TO: All Staff  
FROM: Public Works Plan Review Team  
DATE: September 30, 2021  
SUBJECT: LPF-21-00006 Forest Ridge II Second Review

#### **SURVEY:**

DWN BY	DATE	JOB NO.
T.S.	09/2021	18069
CHKD BY	SCALE	SHEET
M.K.K./D.L.P.	1" = 100'	7 OF 7

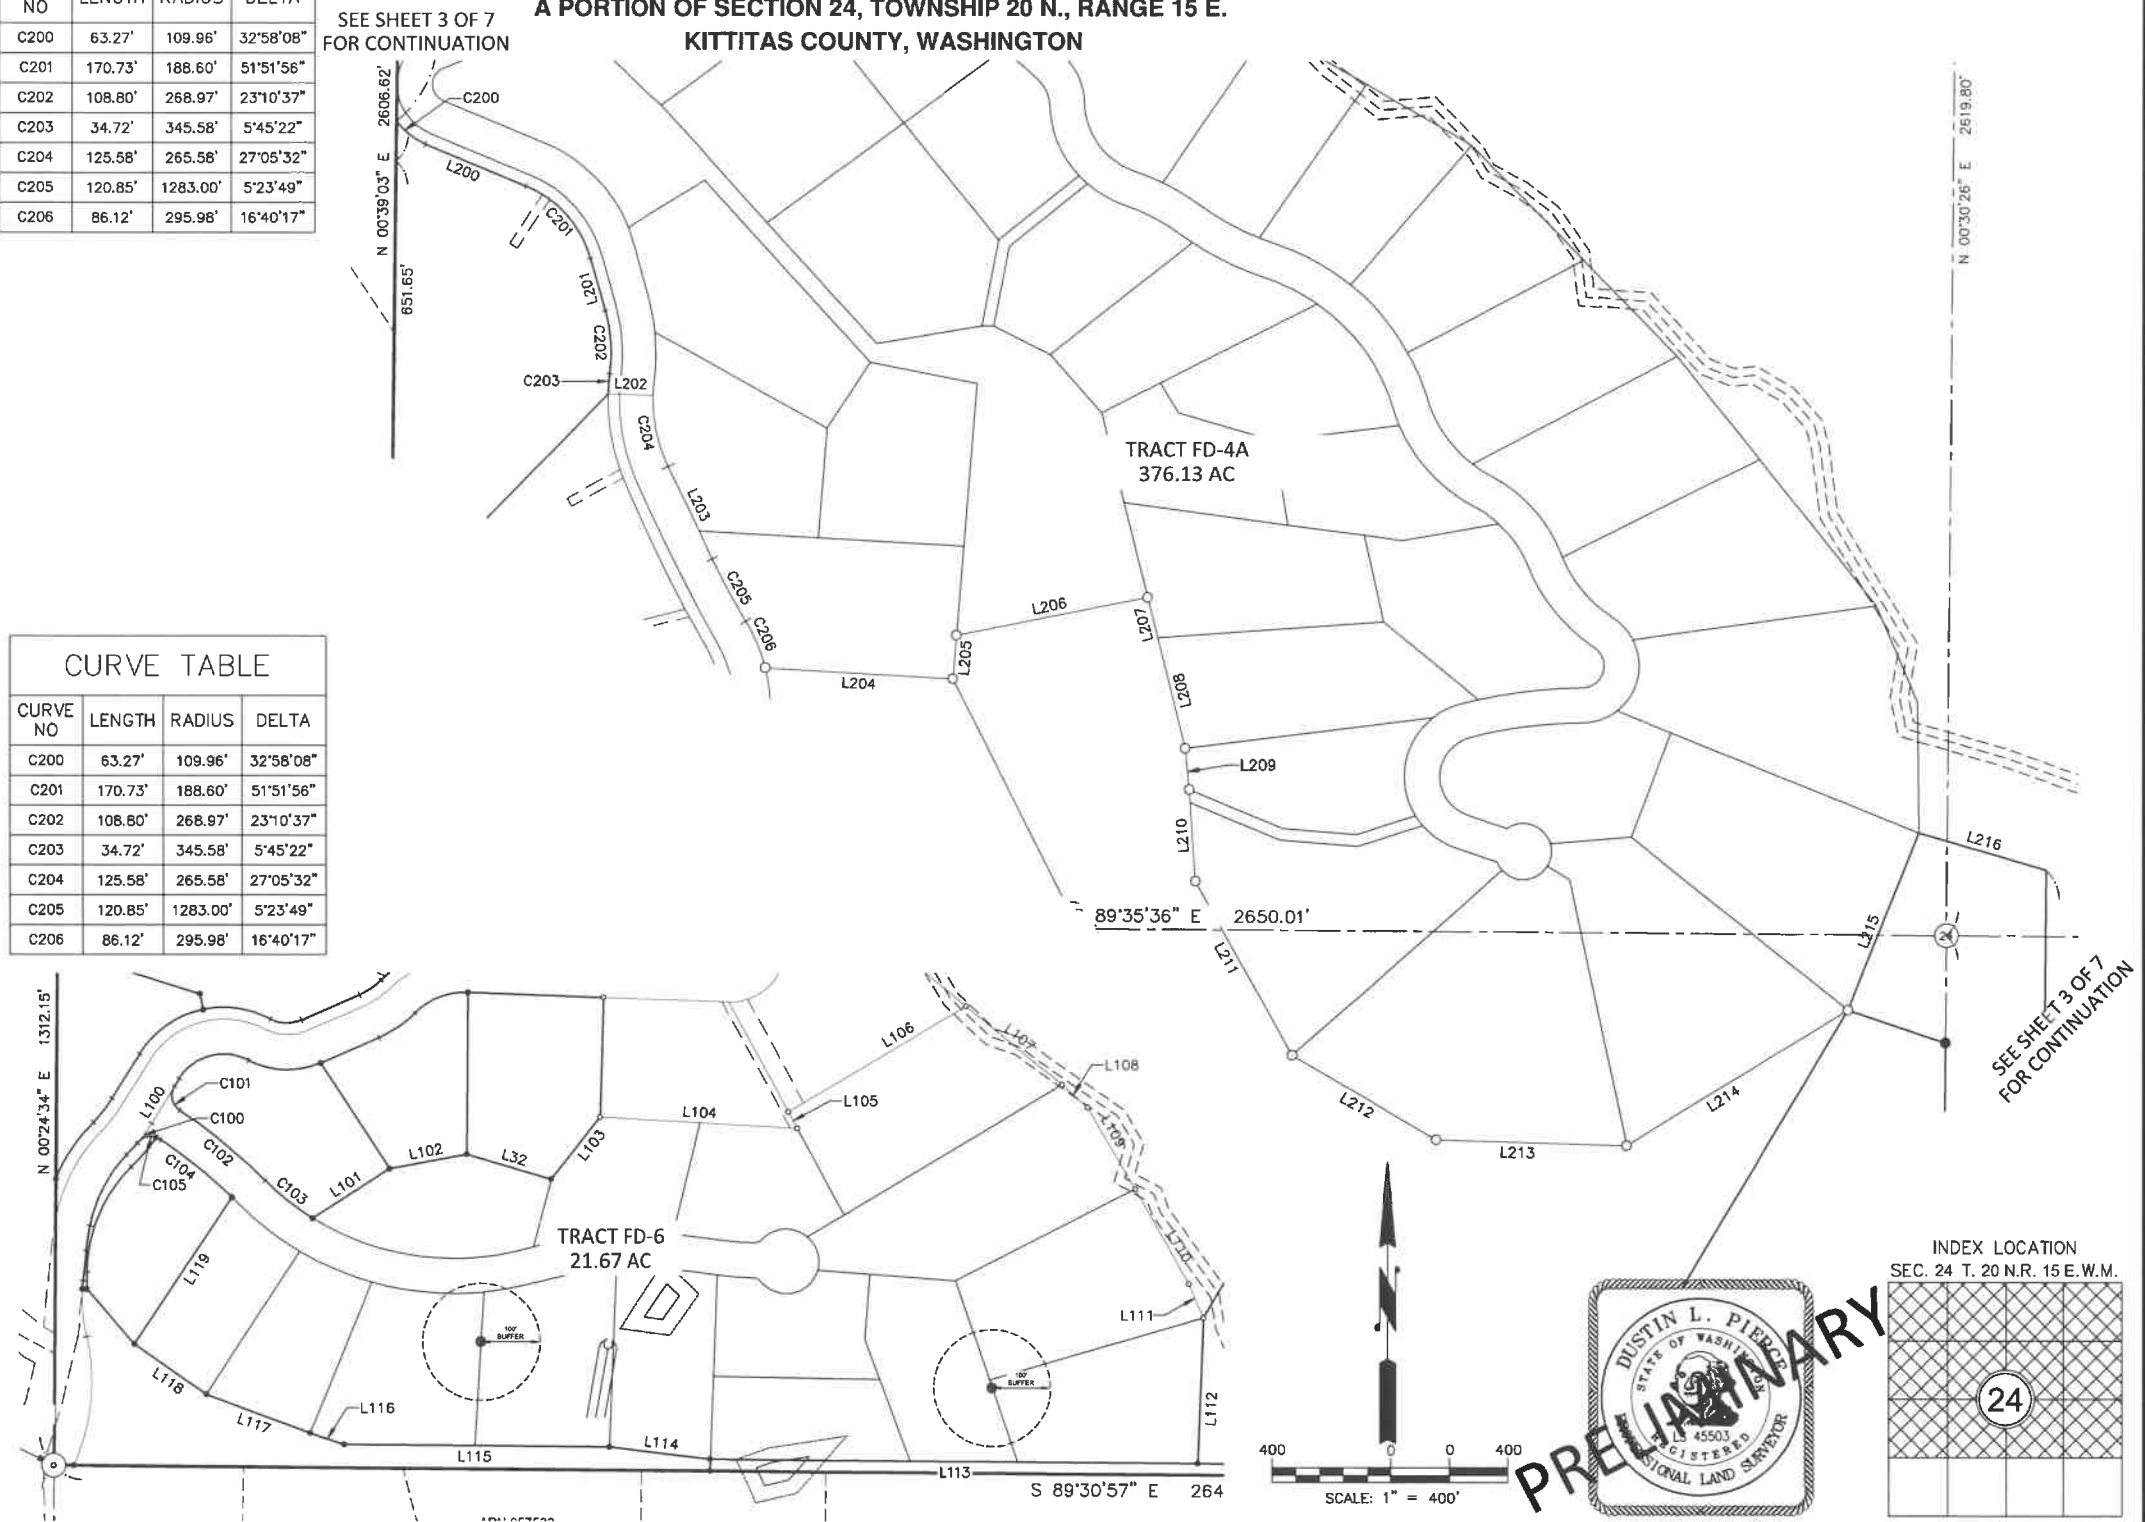
Sheet 7

1. The following Line Tags are obscured by crossing linework: L215, L110, L109, L108, L107.
2. The following Line Tags do not have associated Line Tables shown, but dimensions can be found on other sheets: L32, L100 to L104, L112, L114 to L119, C100 to C105.
3. The following Line Tags do not have associated Line Tables shown: L104 to L111, L113.
4. The following Line Tags do not match the closure report: L210, L203, L202.
